B.A. McCurry
ENGINEERING

11-6-24
 Jon & Lynn Kerien %
 Tarheel Restoration Inc.
 Bruce Robinson; 919-916-9682; brucetarheel.inc@gmail.com
 Engineering- Field Observation Footing Bearing Testing

188 Shady Brook Lane, Fuquay Varina, NC 27526

Project No.:24PG-1028A BAM

Footings/Foundation Plan
scale: 3/16" = 1'0"

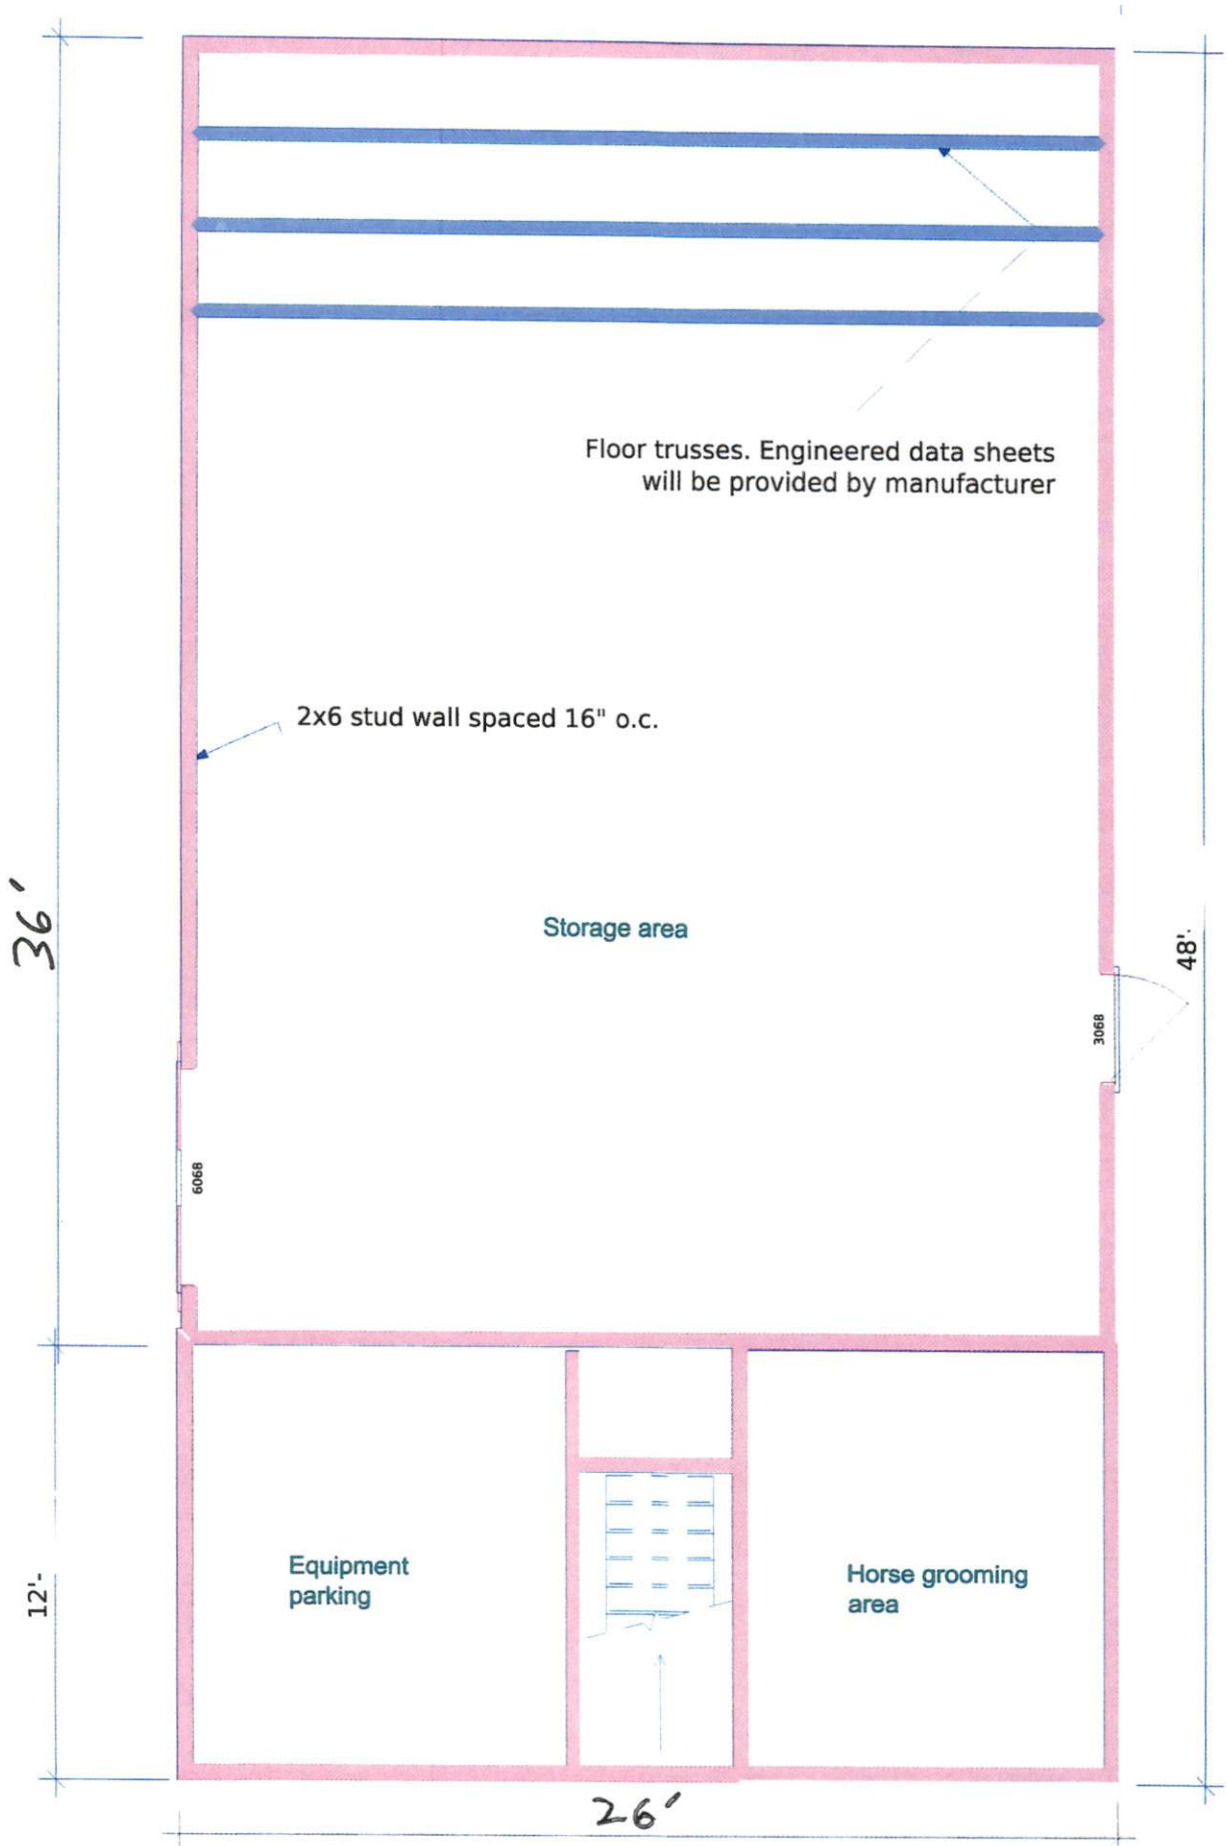
Additionally, the plan drawings provided by the owner were reviewed and used to verify the footing depths (by pins) and width were in place per the plan drawings. The footing depths were greater than the plan dimensions of 8 inches and the widths were greater than the plan dimensions of 16 inches. Two #4 reinforcing steel was observed continuously.
